Our reference: ECM Ref: 9796236
Contact: Kathryn Saunders
Telephone: (02) 4732 8567

6 December 2021

Request for Advice - EIS – 155-217 Aldington Road Estate – SSD-17552047

01 LANDSCAPE SECTION A-A
Scale 1:200@A3

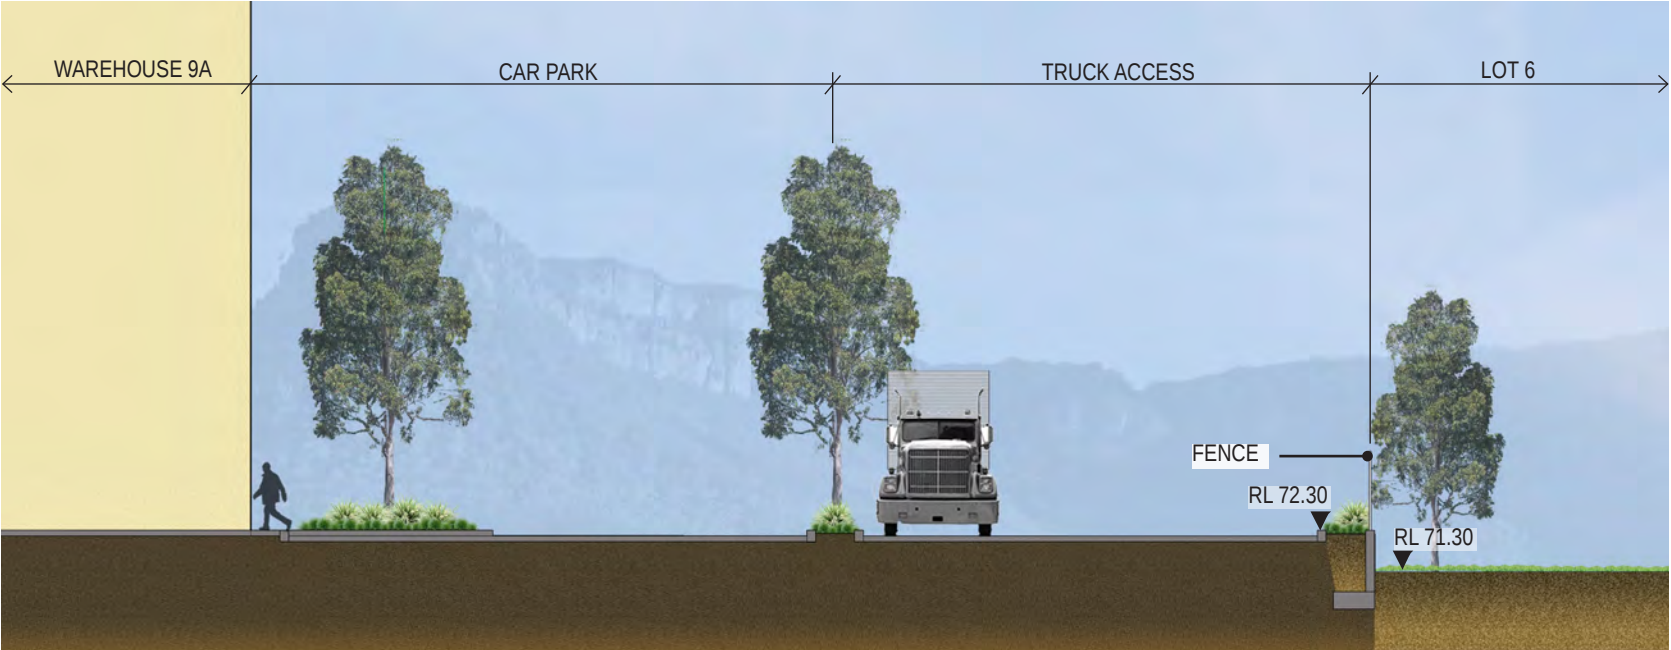
- (h) Signage is to be high quality and better documented and explained. The Mega Graphics are excessive and are considered advertising rather than business identification.
- (i) Trucks and domestic vehicles (staff and visitor) access and parking areas are to be separated.
- (j) Retaining walls are to be setback and stepped in accordance with the DCP requirements. Situations as depicted in Figure 3 below are to be avoided and redesigned.
- (k) Freight

Figure 5: Typical retaining wall section

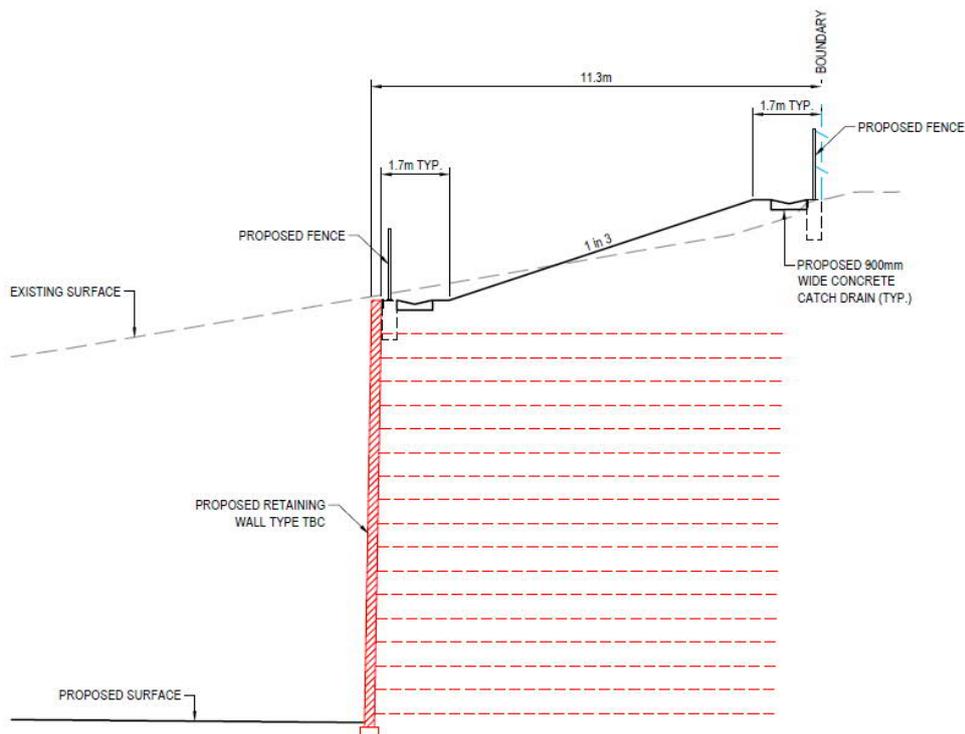
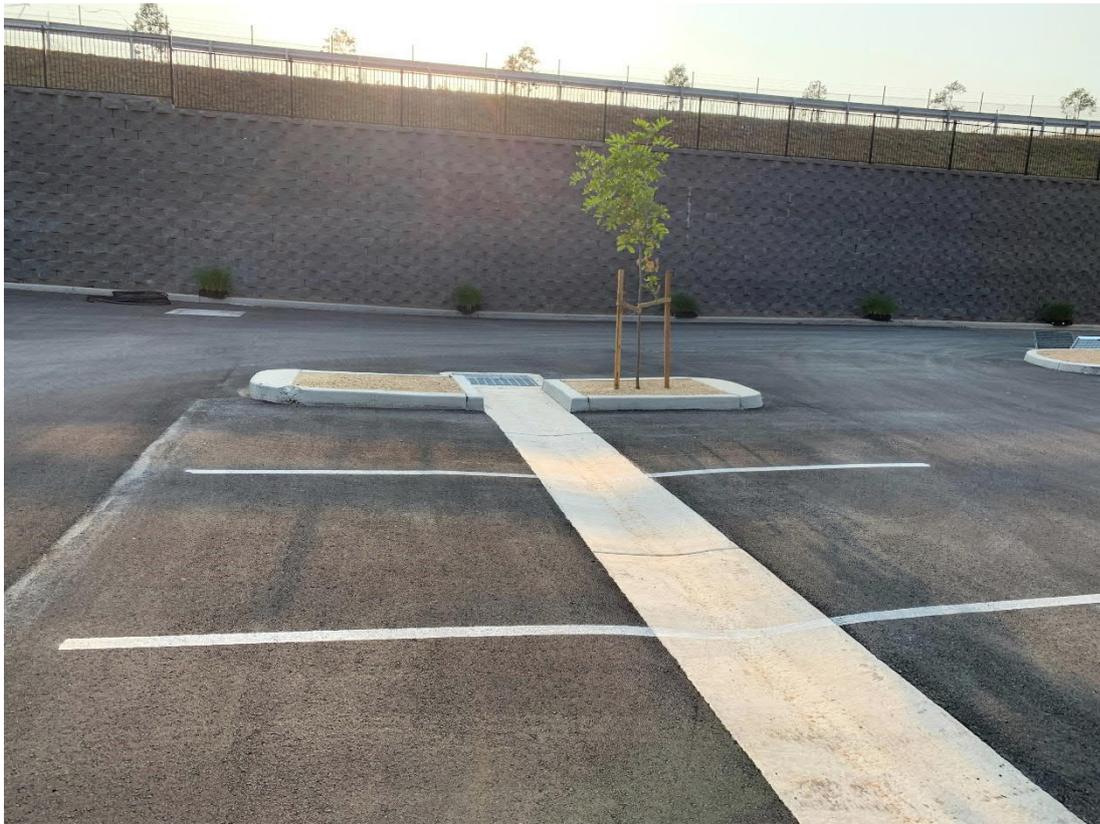
Plans indicate that civil works including battering are proposed outside of the site's boundaries. All works are to be within the site's boundaries or owners consent provided and (existing and future) interface issues addressed.

- Plans shall demonstrate that earthworks and retaining walls comply with objectives and controls of the Mamre Road Precinct DCP Section 4.4 Earthworks and Retaining Walls.
- Any earthworks and batters upon adjoining properties shall include owners' consent for the works.

Figure 9: Typical Section of the proposed Internal roads

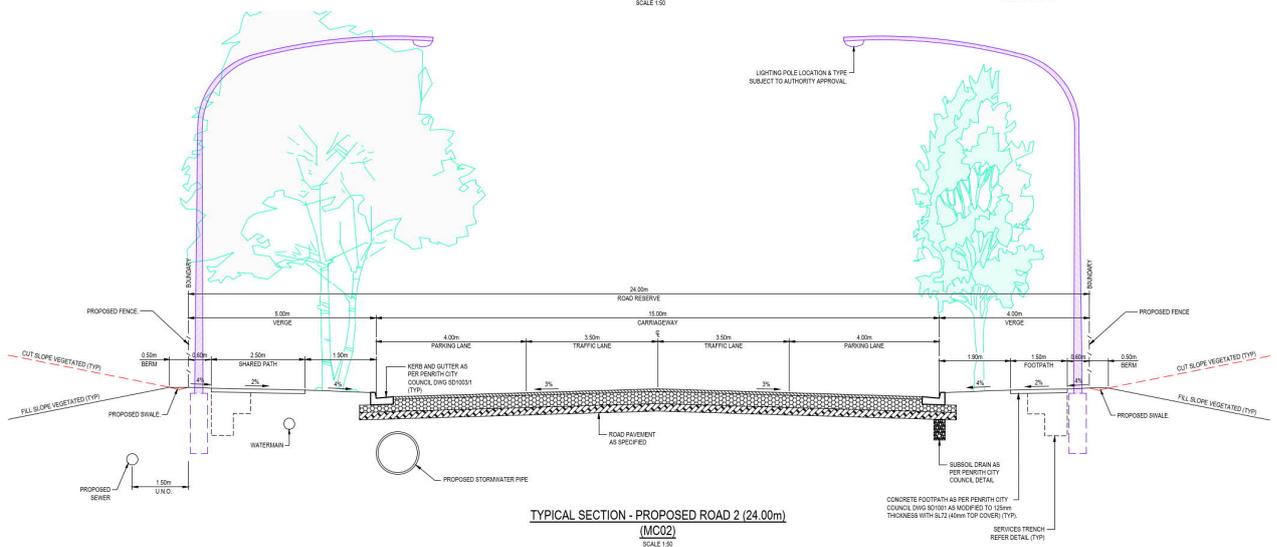
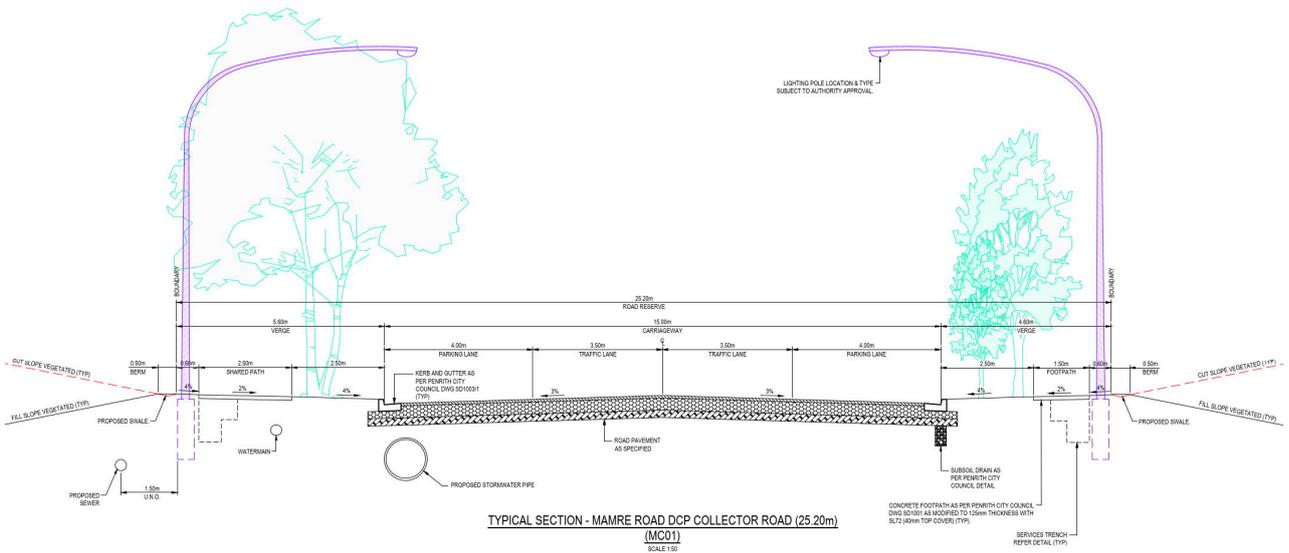
- (d) All internal roads are to be designed compliant with the preferred road typologies of the DCP. Importantly, distributor roads are to be provided with 1.6m wide vegetated central median and are to have a 30.6m wide roadway width. Collector roads are to have a total roadway width of 25.6m (variable to 26.4m at intersections). Roads are to be properly categorised and designed accordingly.

- The architectural plans, engineering plans and the plan of subdivision are to be revised to demonstrate compliance with the Road Typologies of the Mamre Road Precinct DCP. The following items are to be amended:

- o Road No. 1 is to be widened to comply with a Collector Road (Type 2). Setbacks and separated access is are to be amended.
 - o The intersection of Road No. 1 and Aldington Road is to be signalised in accordance with the DCP. A layout for the ultimate signalised intersection of Road No. 1 and Aldington Road shall be provided.
